Application for a non-material amendment following a grant of planning permission.

Single storey rear extension and internal alterations	
Reference number:	H14-0860-21
Date of decision	12/10/2021

0301-21-01 Proposed Rear Extension

0301-21-01A Proposed Rear Extension

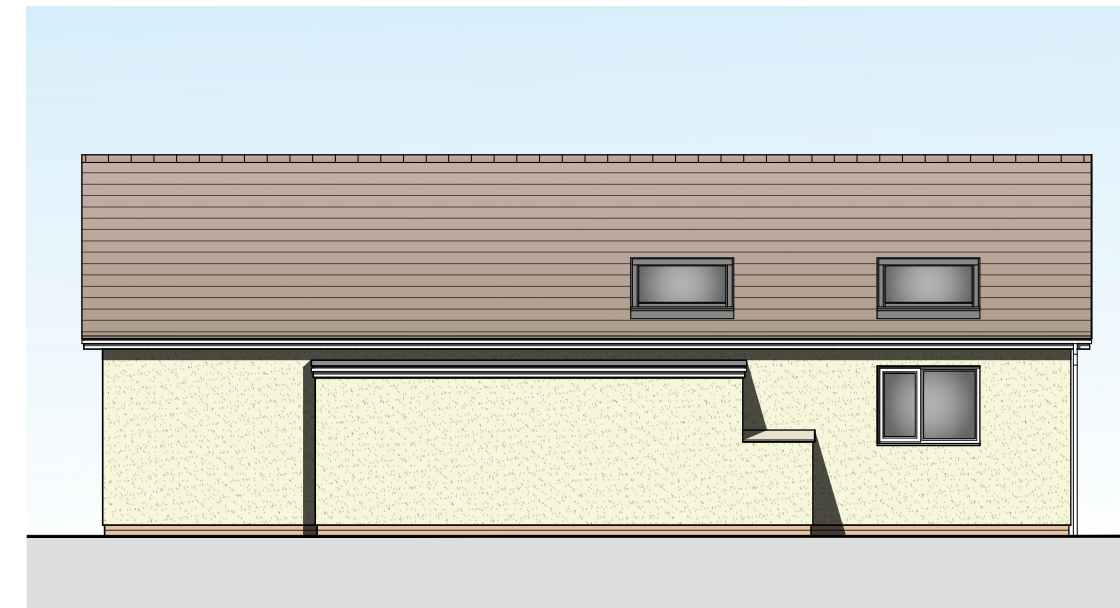
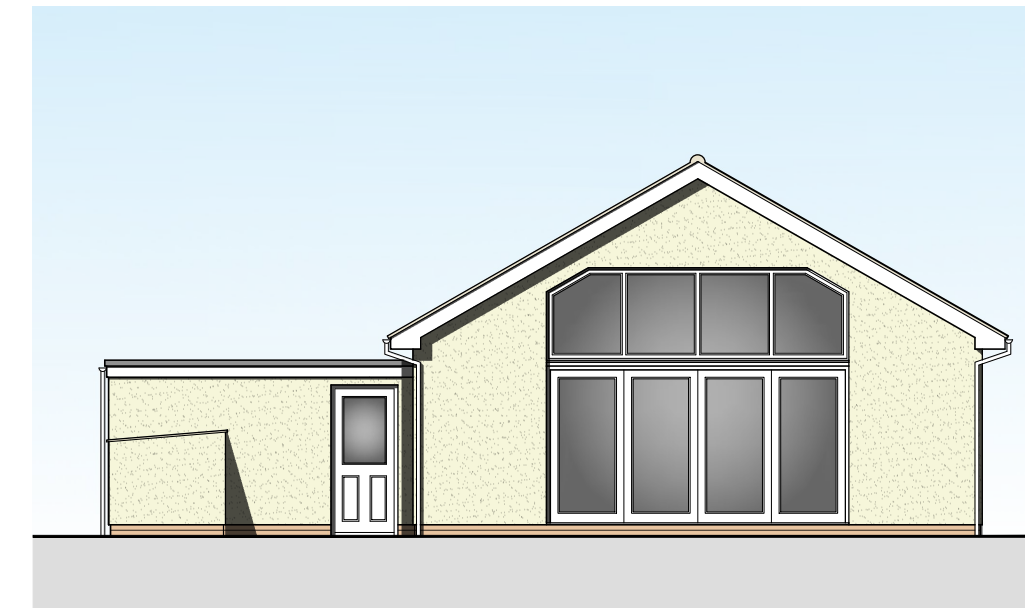
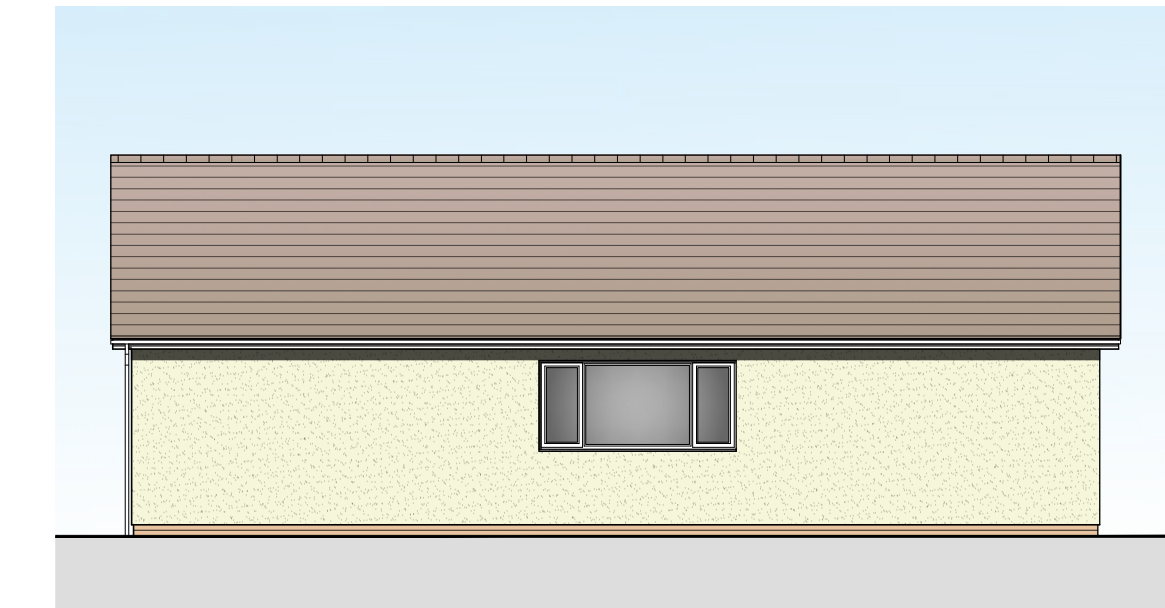
Alteration to the external finish from buff coloured brick to Ivory coloured render.

Client wishes to render the external of the building as the existing brickwork is in poor condition and can not easily be matched.
